From: Dan Young
Sent: Thursday, March 13, 2025 9:49 AM
To: Bradley Gasawski
Subject: RE: RU-25-00001 Immer - Notice of Application

Subject: RU-25-00001 Immer - Notice of Application

TO: All Staff
FROM: Public Works Plan Review Team
DATE: March 26, 2025
SUBJECT: RU-25-00001 Immer

SUBJECT: WDFW COMMENTS RU-25-00001 Immer

# PROPOSED SITE PLAN

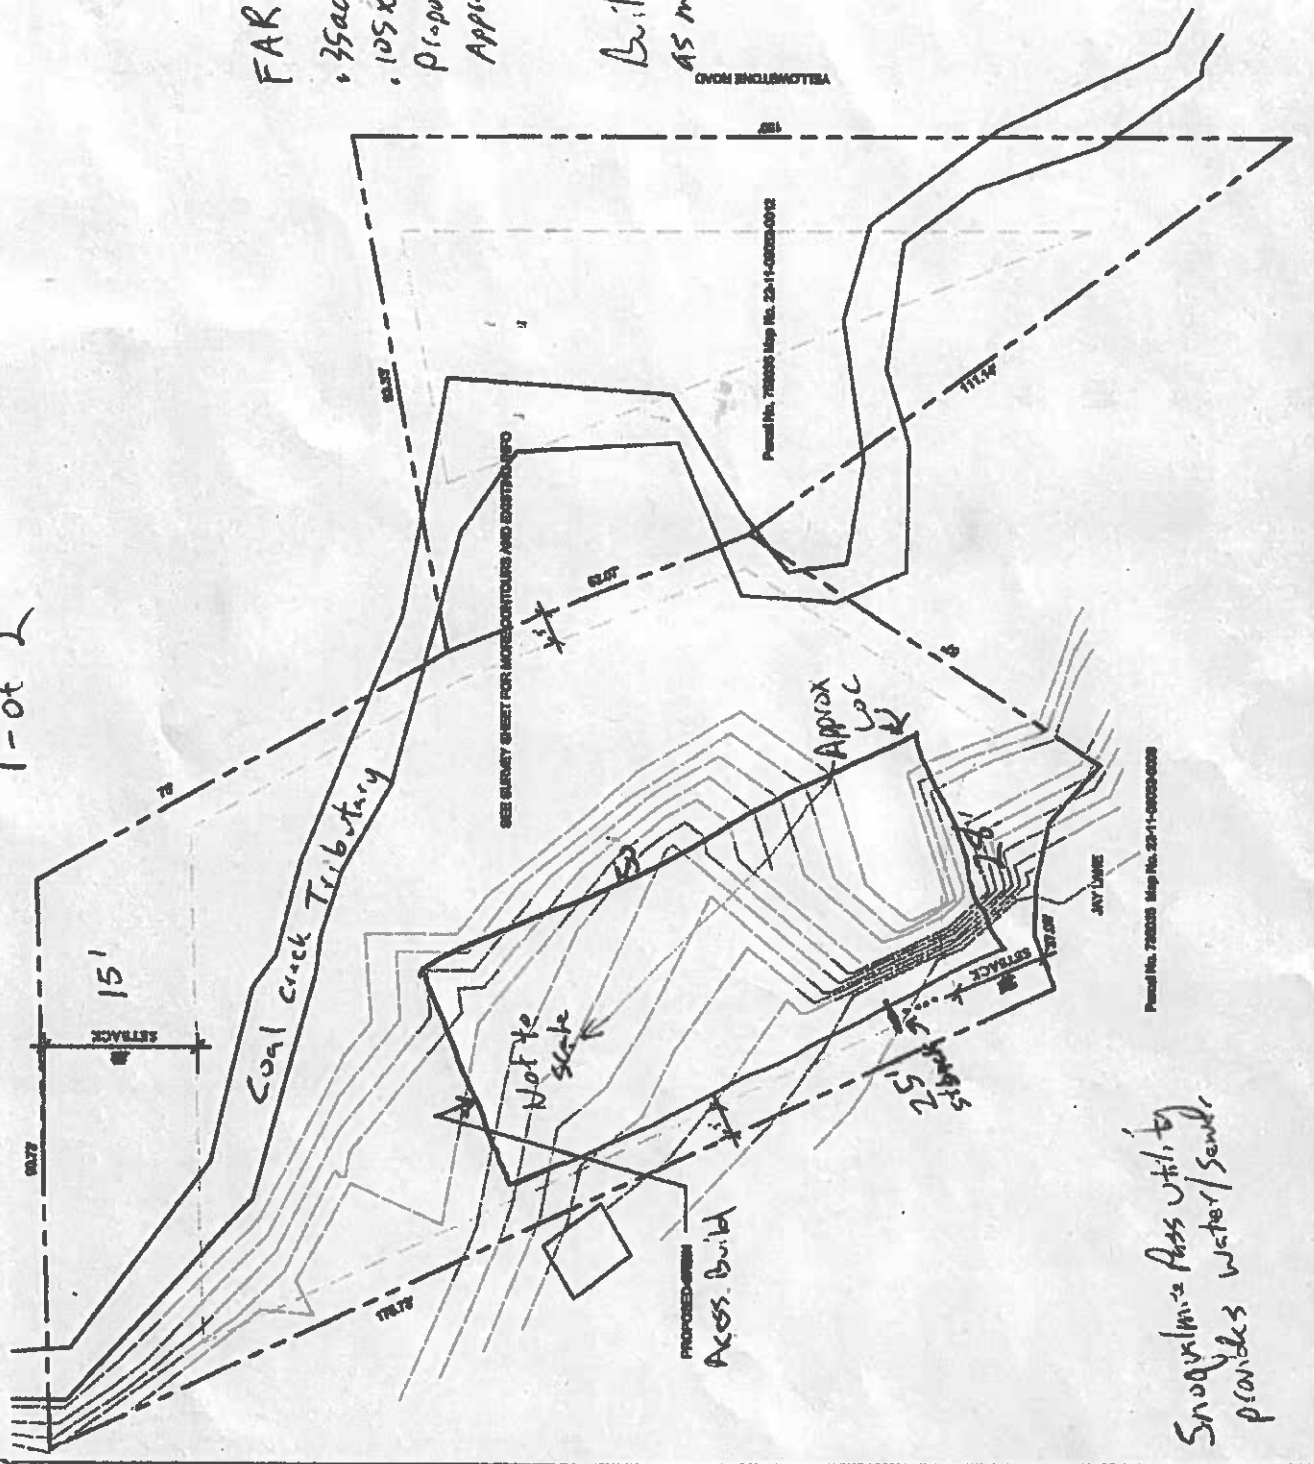
According to the site plan submitted by the applicant, the Snoqualmie Pass Utility District will provide water and sewer. I've attached the site plan to this email and the link to view the files is provided in the email below should you decide to further review the submitted application materials.

1. What is the source for drinking water for the building?

SURVEY	Given that the proposed building site is to be a close as possible to setback lines, I propose that a licensed land surveyor be utilized to stake out the building envelope, in order to ensure that the building does not encroach on neighboring parcels. (JT)
TRANSPORTATION CONCURRENCY	No transportation concurrency requirement for this project. (KAH)
FLOOD	Parcel #738035 is not mapped within a FEMA identified special flood hazard area (100-year floodplain). A floodplain development permit is not required for the proposed project. (SC)
WATER MITIGATION/ METERING	No comments. (SC)
AIRPORT	No comments. (JS)
